Consultee Comments for Planning Application 21/01507/FUL

Application Number: 21/01507/FUL

Address: Pine Tree Cottage Camp Road Sutton Coldfield Staffordshire B75 5QX

Proposal: Erection of 2no detached three bedroom dwellings

**BLOCK PLAN**

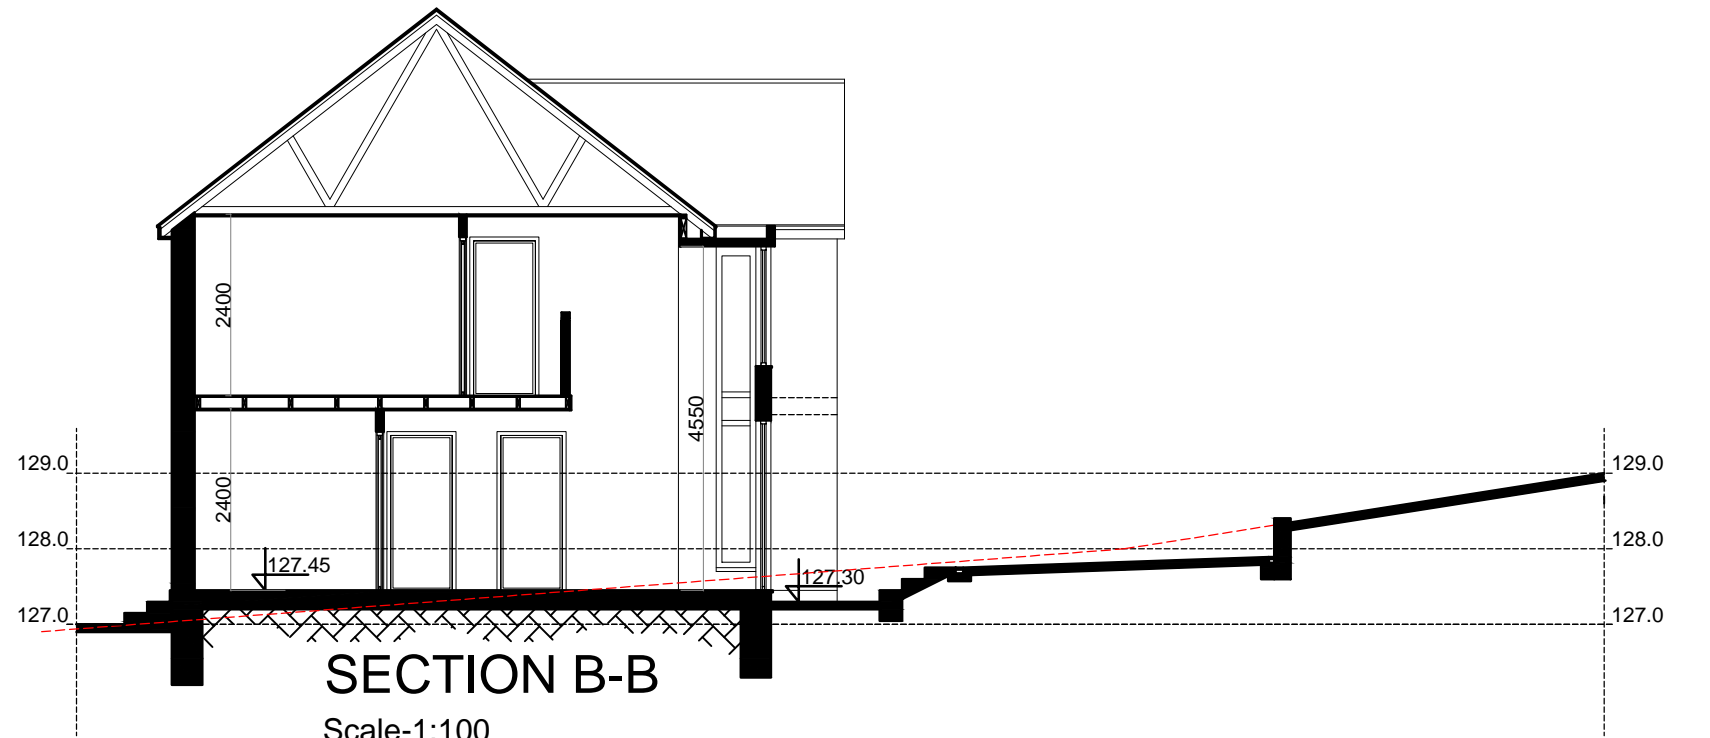
Whilst the site is not within any designated conservation area and currently there are no TPO's, it does appear that there are a number of large trees affected some of which may be on third party land. We note that the adjacent woodland, Hovel Covert, is an Ancient Semi Natural Woodland designated on Natural Englands Ancient Woodland Inventory. We will need to see this designated boundary displayed and the distances to the proposed development must be detailed and in line with guidance.

We also observe that the access road is also heavily constrained by third party trees and the impact on these has not been considered in the submission.
